Your Ref: OWPC21146
Our Ref: Y/103/18/PL 24-12-2018
Please ask for:
Mr S Davis

Single Chapel Crematorium with car parking, landscape works, surface water drainage features & associated highway improvements. This application is a Departure from the Development Plan.

10 Acre Field North of Grevatts Lane Yapton

OBJECTION TO Y/103/18/PL

PBA drawing 128.001.007 Rev D

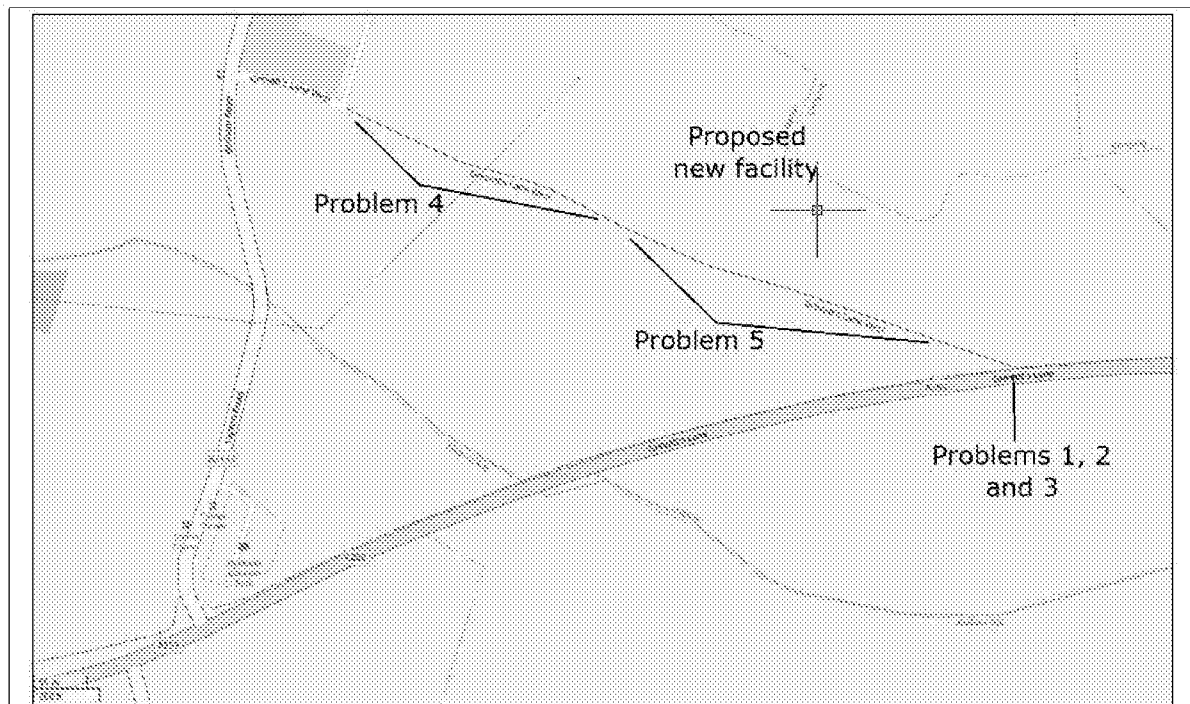
- The proposal seeks to create a junction comprising two slip roads off the A259. Traffic from the west will turn left into Grevatts Lane West on a slip road which is about 7m wide. There is then a central reservation, which will presumably be used by cyclists and pedestrians, with a further two lane in/out junction to allow traffic from the east to enter Grevatts Lane West and all traffic to leave the site either to the east or west. That is over 7m wide. This entrance will cut across the recently installed cycleway/footpath.*

- The proposed junction is on an unlit section of the A259 with a 60 mph speed limit. With slow moving corteges regularly moving along this section of road, it will have an adverse impact on other motorists, particularly as the corteges slowly turn off the A259 to access the crematorium. This must increase the risk of accidents particularly on winter afternoons when light levels are low.*

- When vehicles wish to leave the crematorium, they will tend to do so in groups and will all be trying to turn left or right on to the A259. The experience of Comet Corner and The Oystercatcher junctions are that it can be particularly difficult to turn right (towards Bognor Regis) at any time of the day. Given the proposed new junction is equidistant from the existing junctions it is reasonable to assume that if say 10 or 15 vehicles try to leave the crematorium at about the same time there will be peer pressure on the car at the junction to take a risk when pulling out.*

- Further, past experience has shown that when there are breaks/junctions created in cycle paths, many cyclists will not use them, instead returning to the main carriageway to*

avoid the need to slow down, wait to cross the junction and then start again to regain speed. That will then negate the reason for the recently opened cycle path and the substantial costs in its creation. There is also an increased risk of accidents on this unlit section of "A" road.
